St Luke's Grammar School - Senior School Campus and Sports Centre (SSD-10291)
Response to Submissions

The Department has also undertaken a detailed assessment of the proposal and identified key issues in **Attachment 1**, that are required to be addressed in the RTS and updated technical supporting documents.

Attachment 1

DRAWING TITLE
GENERAL
SITE PLAN

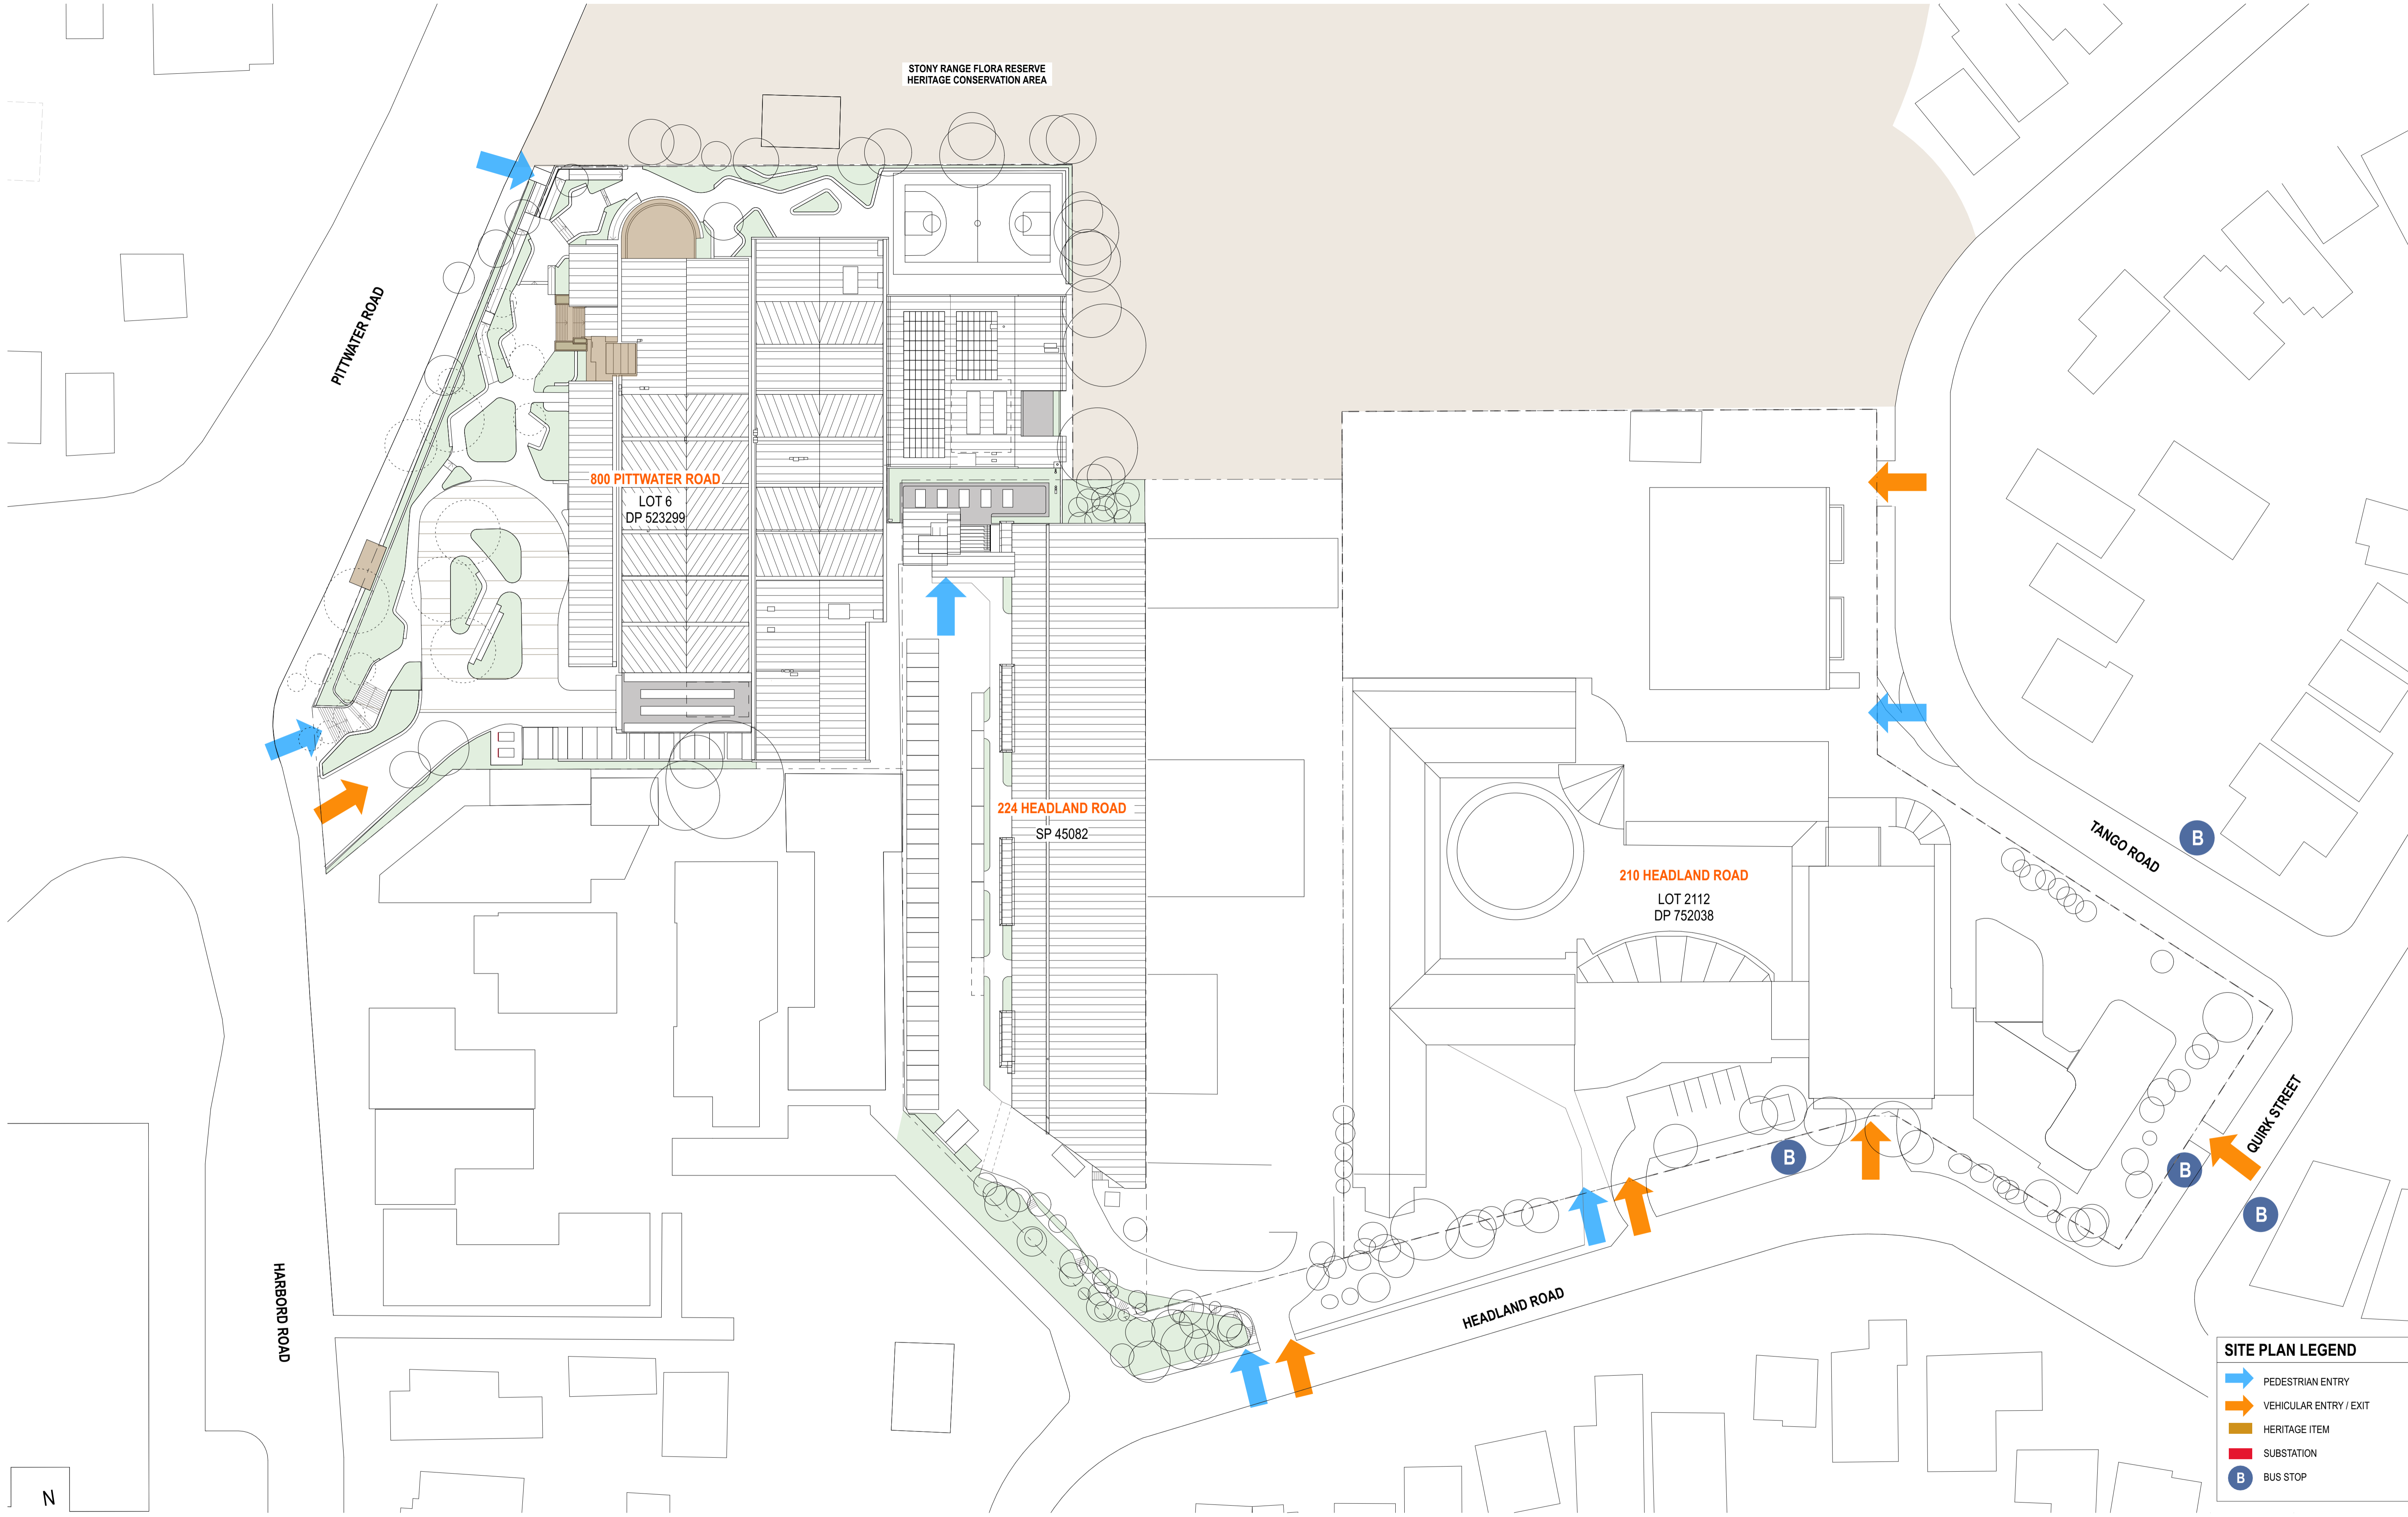
- The Department notes that Transport for NSW (TfNSW) have raised concerns regarding the increase in pedestrian / vehicle conflicts associated with the Harbord Road driveway providing access to the senior school campus at 800 Pittwater Road. The Department agrees with the above concern. Noting the proposed change of use of the premises, the Department requires you to:

- investigate the feasibility of an alternative access point to the site, including the closure of the Harbour Road driveway. Or
 - demonstrate that the existing driveway can operate safely in the future ameliorating the identified risks.

DRAWING TITLE
800 PITTWATER ROAD
SIGNAGE PLAN
SCALES AT A1
1:500, 1:200
PHASE
SSDA
DRAWING NO
A-004

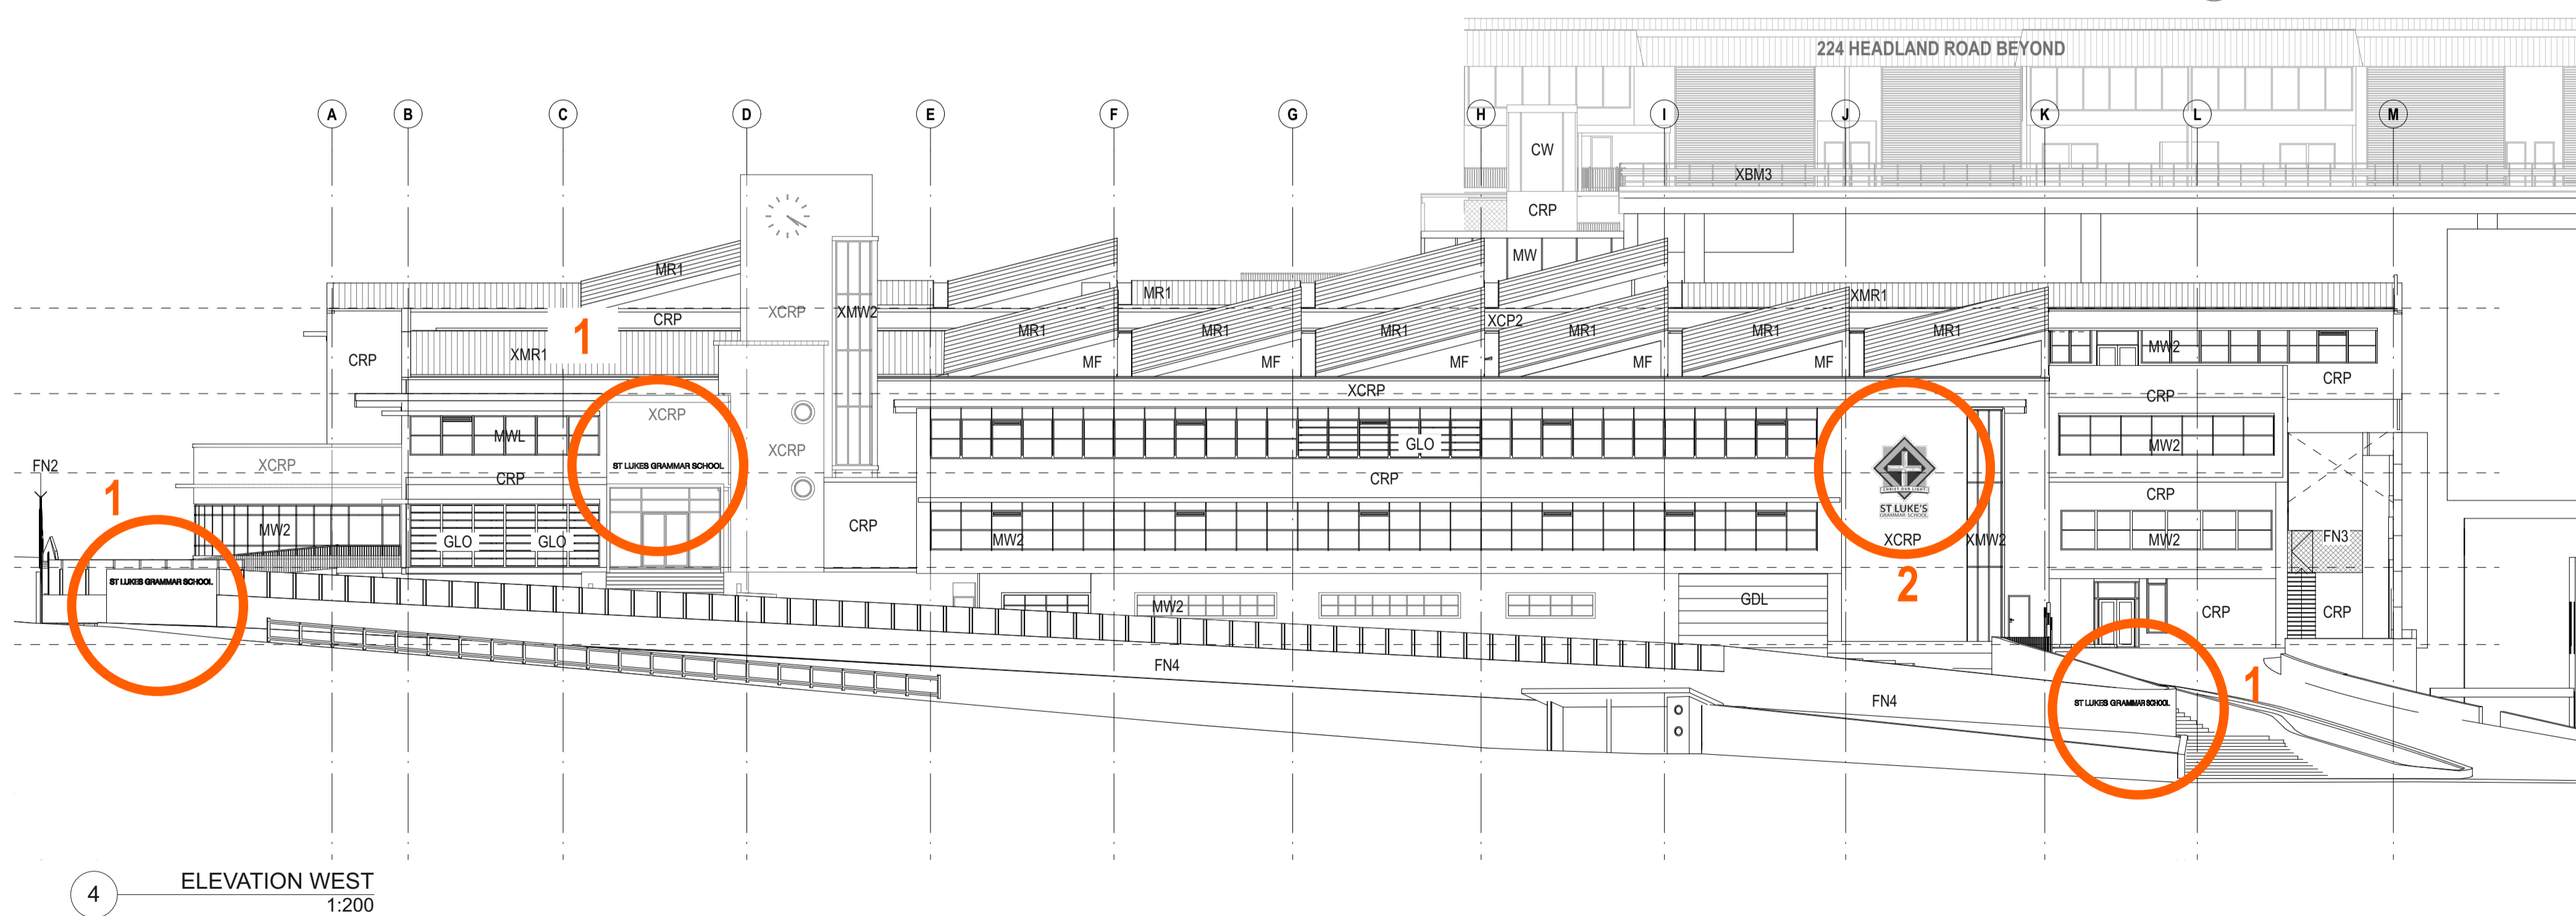
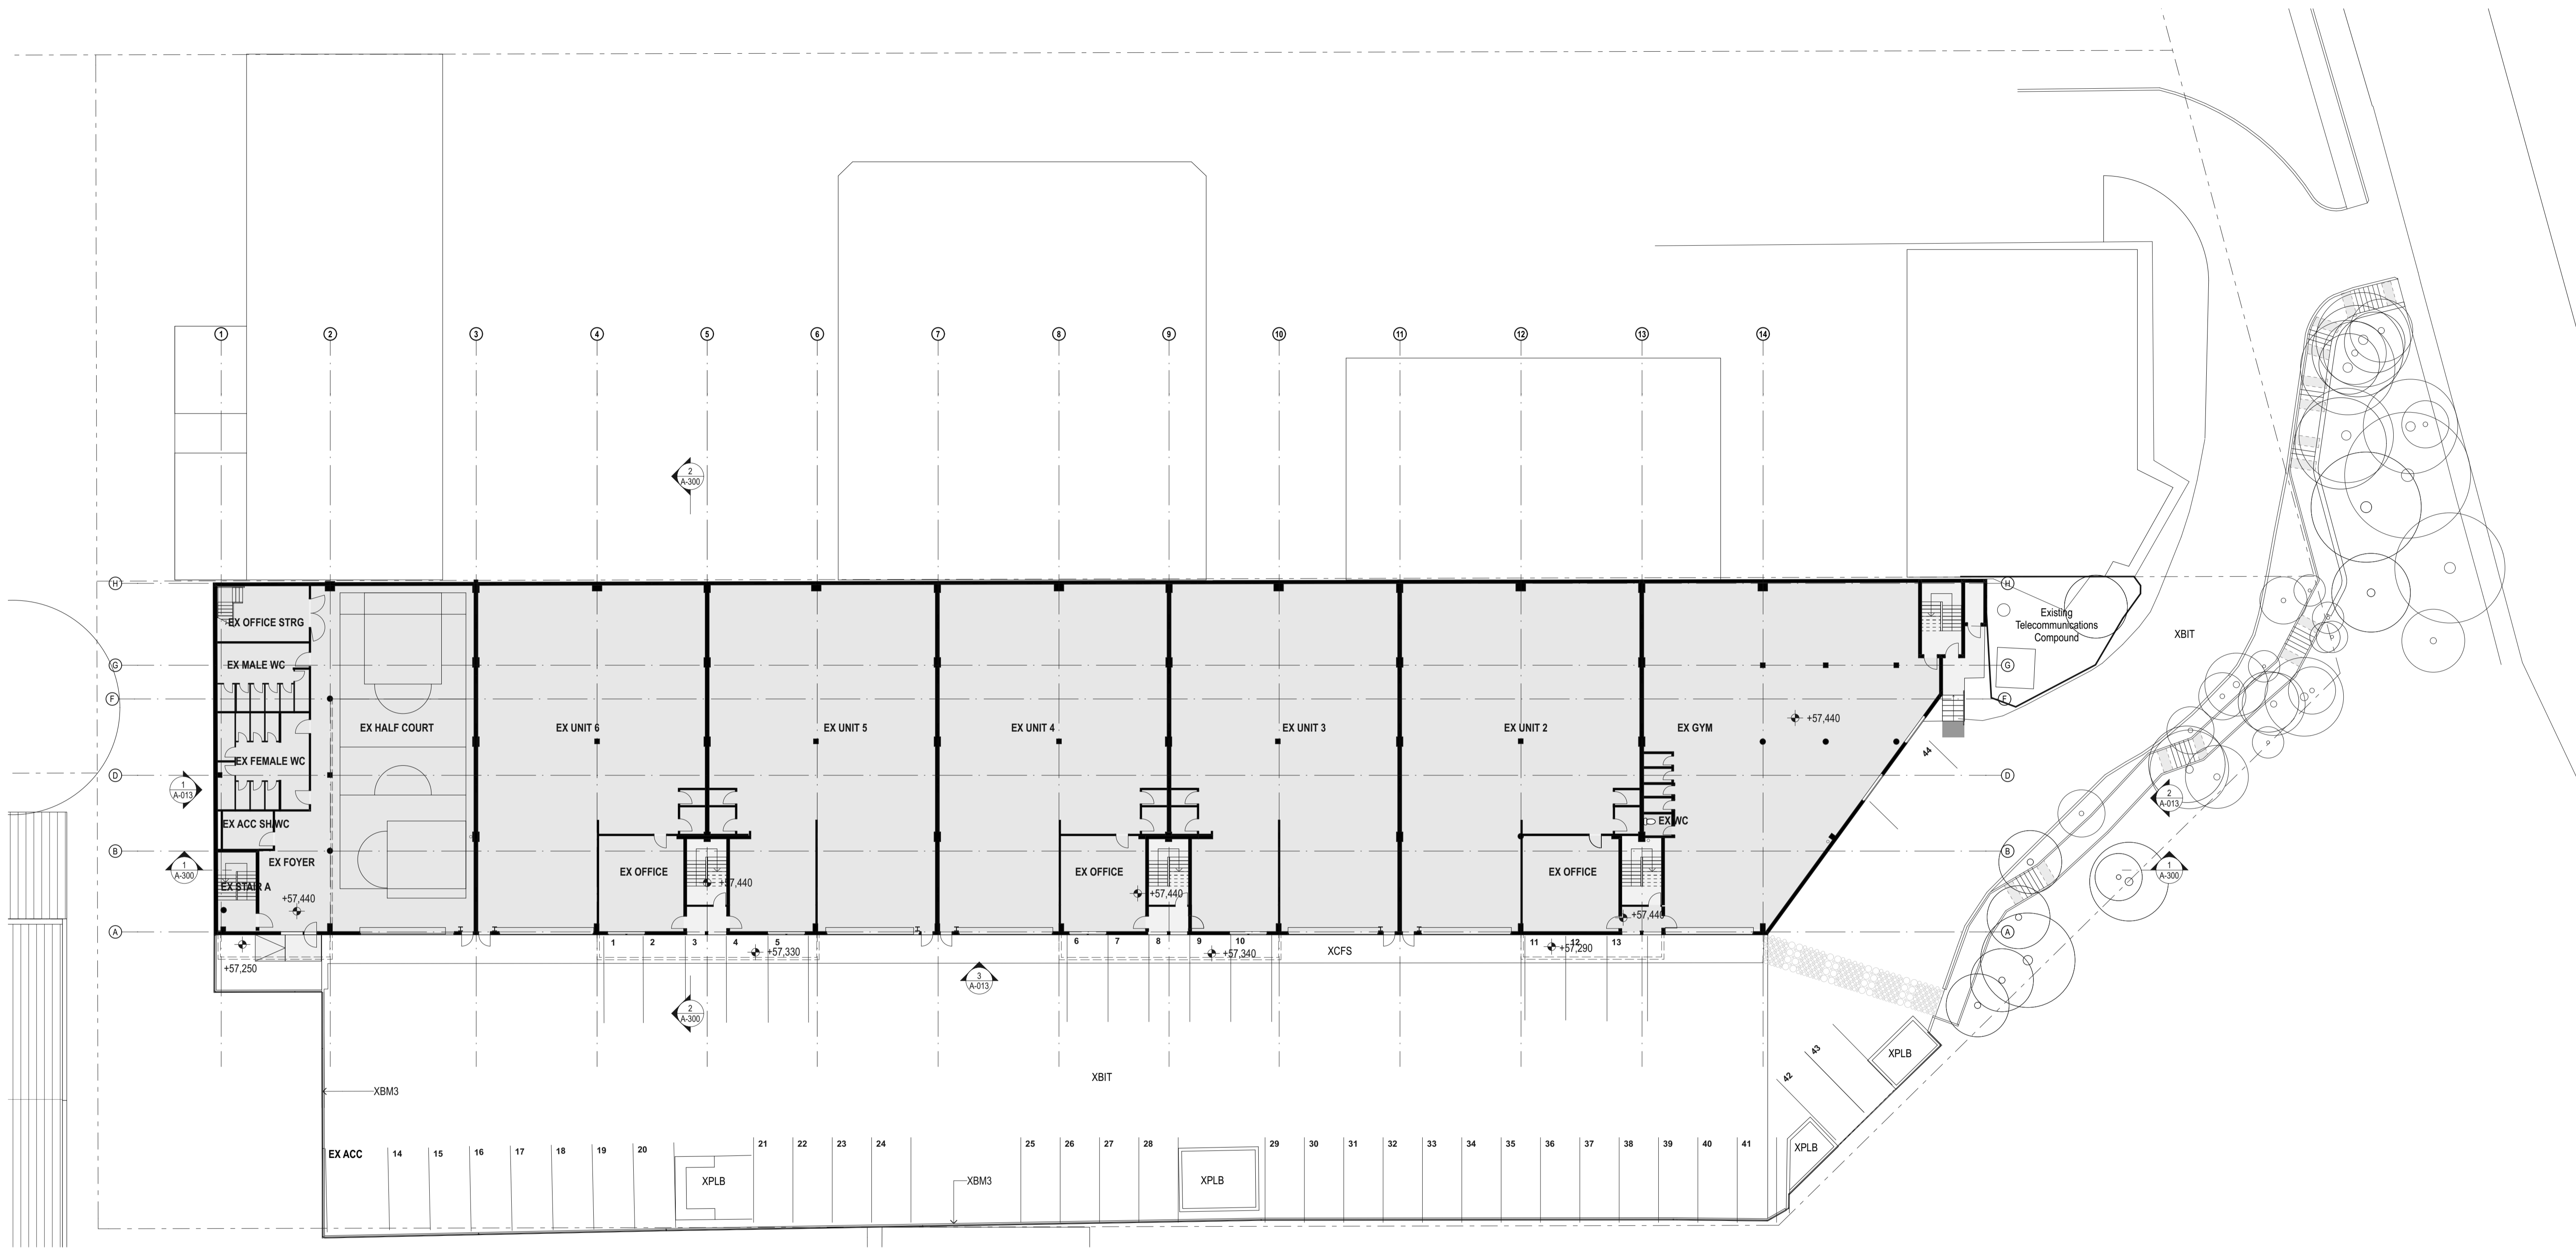
- Prior to the lodgement of the EIS, the State Design Review Panel recommended the reduction in the use of transparent materials such as plexiglass or acrylic material. The design of the fence along Pittwater Road incorporates an acrylic material on top. The RTS should justify that the use of the material responds appropriately to the previous State Design Review Panel comments.
- The Department concurs with the comments from Northern Beaches Council (Council) regarding the provision of a second elevator to connect the two sites and the revision to the roofline at 800 Pittwater Road, and considers that this should be addressed in the RTS.
- The details of the condition and capacity of the pedestrian path from the senior campus to Headland Road must be provided to demonstrate that it would satisfactorily cater as a walking path for the senior school students.
